## Meeting note

<b>Project name</b>	A585 Windy Harbour to Skippool Improvement Scheme
<b>File reference</b>	TR010035
<b>Status</b>	<b>Final</b>
<b>Author</b>	The Planning Inspectorate
<b>Date</b>	21 August 2018
<b>Meeting with</b>	Highways England
<b>Venue</b>	Temple Quay House, Bristol
<b>Meeting objectives</b>	Comments
<b>Circulation</b>	All attendees

## A585 Windy Harbour to Skippool: Comments on the draft Land Plans and Works Plans

Drawing number **HE548643-ARC-HGN-SZ\_ZZ\_000-DR-D-3074**

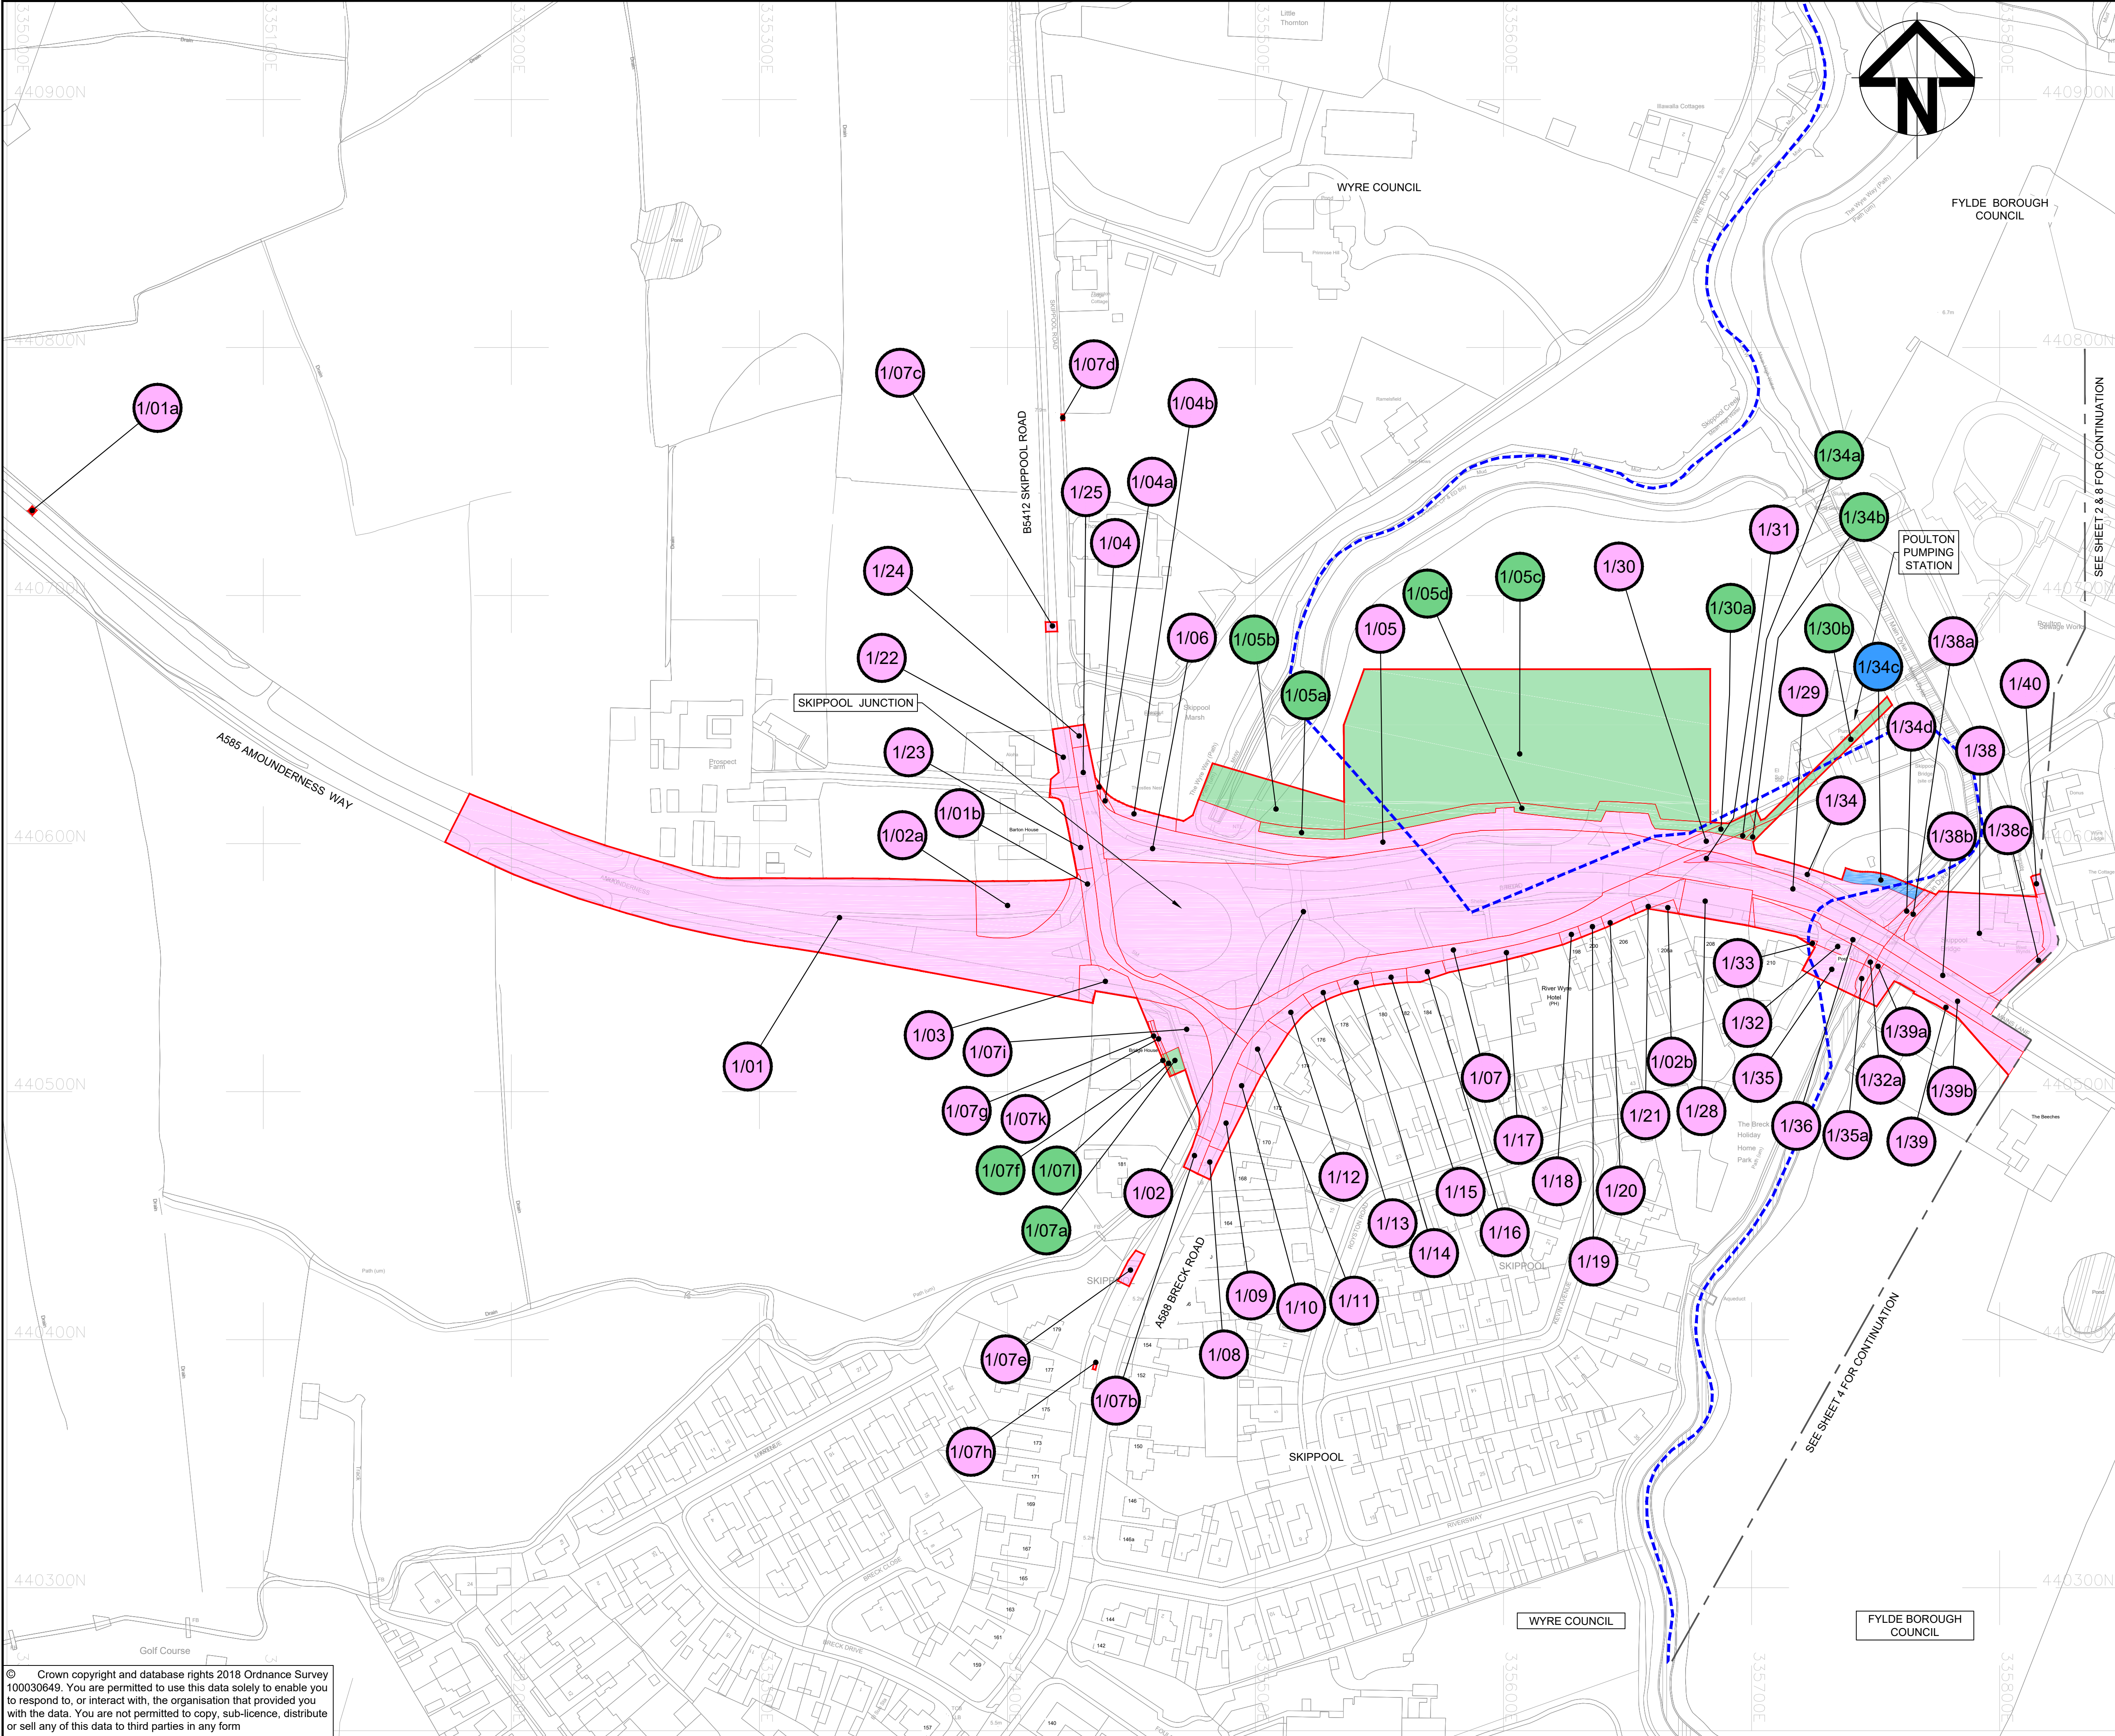
8.	Land Plans	Plots outside of the red line boundary	<p>Plots 1/7c and 1/7e which are identified as land to be acquired permanently, appear to both be outside of the red line boundary, on both the Key Plan and Sheet 1.</p> <p>Plot 2/04a which is identified as land to be acquired permanently, appears to be outside of the red line boundary, on both the Key Plan and Sheet 2.</p> <p>Please ensure all plots that are to be included within the Development Consent Order Application have been included within the redline boundary, consulted on appropriately and included within the appropriate supporting application documents. Or that the redline boundary appropriately covers all relevant land.</p>

<b>10.</b>	Land Plan Sheet 1	Plots with more than one plot reference	There are several plots with more than one plot reference, examples listed below: <ul style="list-style-type: none"> <li>• 1/5 and 1/29</li> <li>• 1/5a and 1/29a</li> <li>• 1/5b and 1/29b</li> <li>• 1/5c and 1/29c</li> <li>• 1/5d and 1/29d</li> <li>• 1/44 and 1/47</li> </ul>
<b>11.</b>	Land Plan Sheet 1	Plots without plot references	There is a plot between Plot 1/28 and Plot 1/33 identified as land to be acquired permanently, which does not have a plot reference.  There is a plot between Plot 1/6 and Plot (1/5a 1/29a) identified as land to be acquired permanently, which does not have a plot reference.
<b>12.</b>	Land Plan Sheet 2	Unidentifiable plot	Plot reference marker 2/04 appears to not be attached to a plot.
<b>13.</b>	Land Plan Sheet 2	Colour coding	It is unclear from the land plan whether Plots 2/01i and 2/06 are land to be acquired permanently, or land to be used temporarily and rights to be acquired permanently.

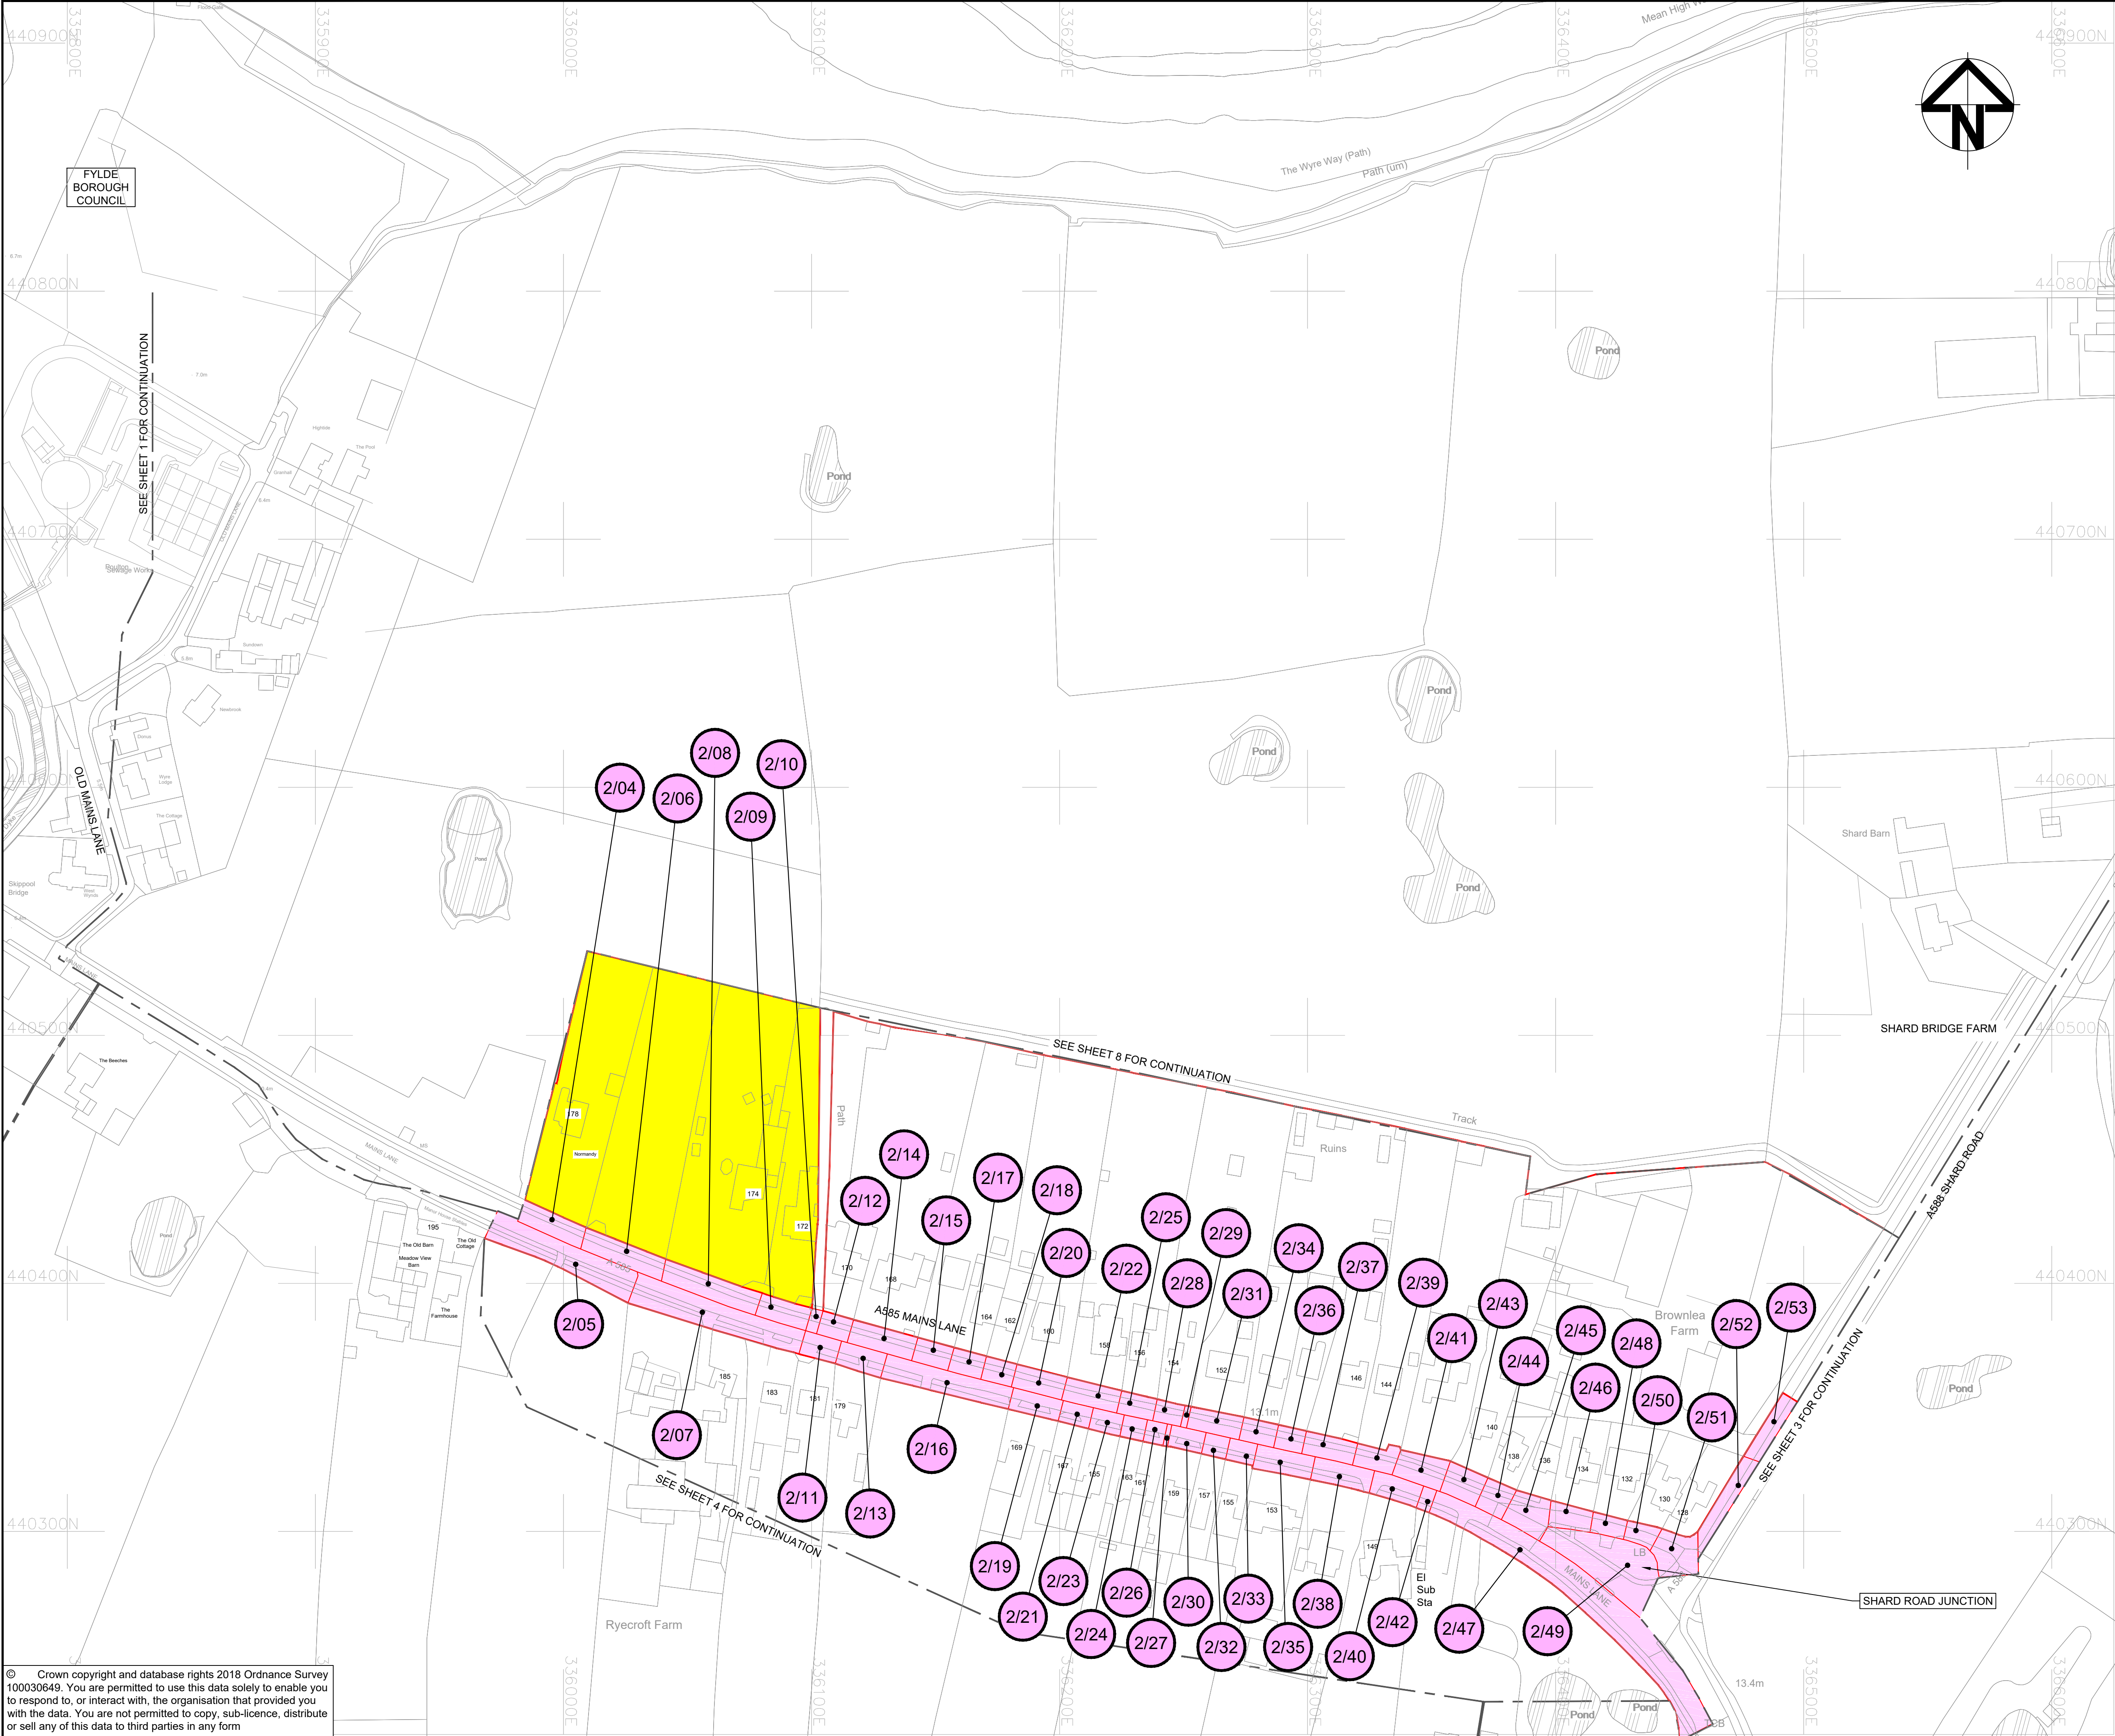
5.	General	Identifying plots which continue across individual sheets	<p>Plot 4/02a is identified on sheet 4, but not identified on sheet 3.</p> <p>Plots 3/01, 3/01a, 3/01b, 3/02, 3/02a and 3/01c are identified on Sheet 3 but not identified on Sheet 2</p> <p>Each plot which continues across more than one sheet should be identified on each sheet to which it relates.</p>

9.	Land Plan Sheet 2	Incomplete red line boundary	A section of the red line boundary is missing, where the road marking of the A585 Mains Lane is identified on both the Key Plan and Sheet 2.
